Application no: 3/20/0036

Address: Land to Rear 28 Calfcote Lane, Longridge
Proposal: Proposed Detached Dwelling.

Dave Bloomer
Development Support
Lancashire County Council

Proposed Block Plan

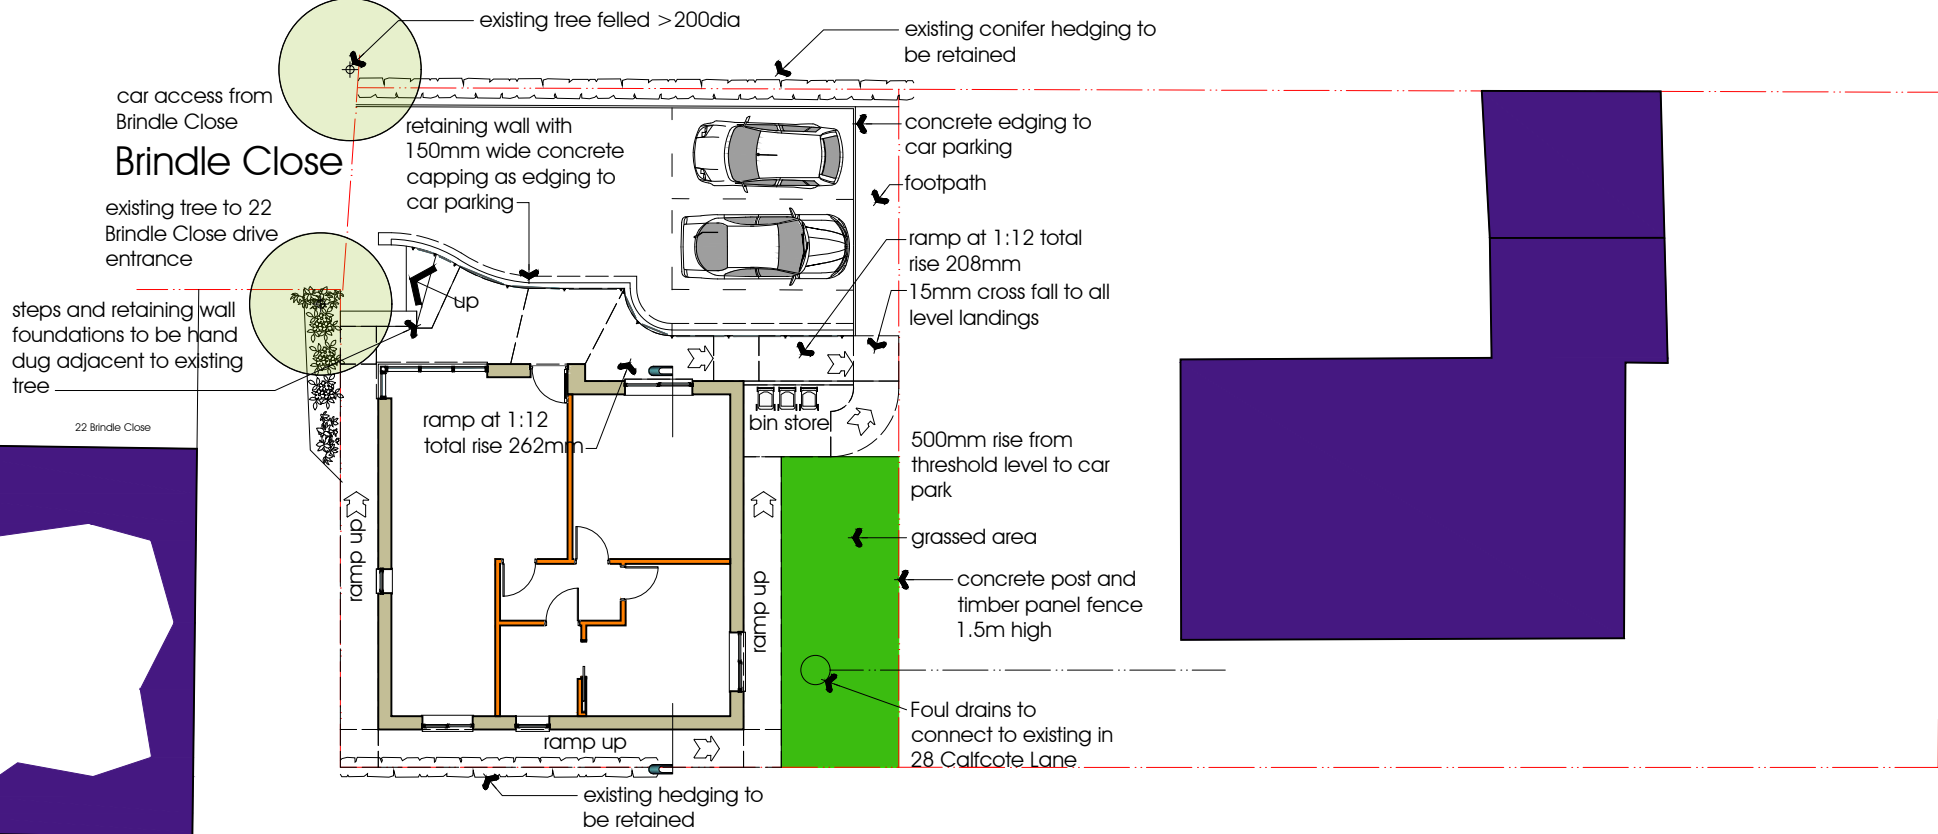
The proposal is for the erection of a detached dwelling in the rear garden of No. 28 Calfcote Lane Longridge with access to the property formed from the turning head on Brindle Close.

Whilst there has been some concerns raised regarding the formation of the access from Brindle Close, there is sufficient highway frontage along this boundary to allow the construction of the proposed access. It will be the responsibility of the contractor to ensure that the needs of local residents is not compromised during the construction phase and the applicant should consider whether or not it is feasible to utilise the existing access off Calfcote Lane during the construction phase.

As proposed I would raise no objection to the proposal on highway grounds but should your council be minded to approve this application I would request that the following note be attached to any permission that may be granted.
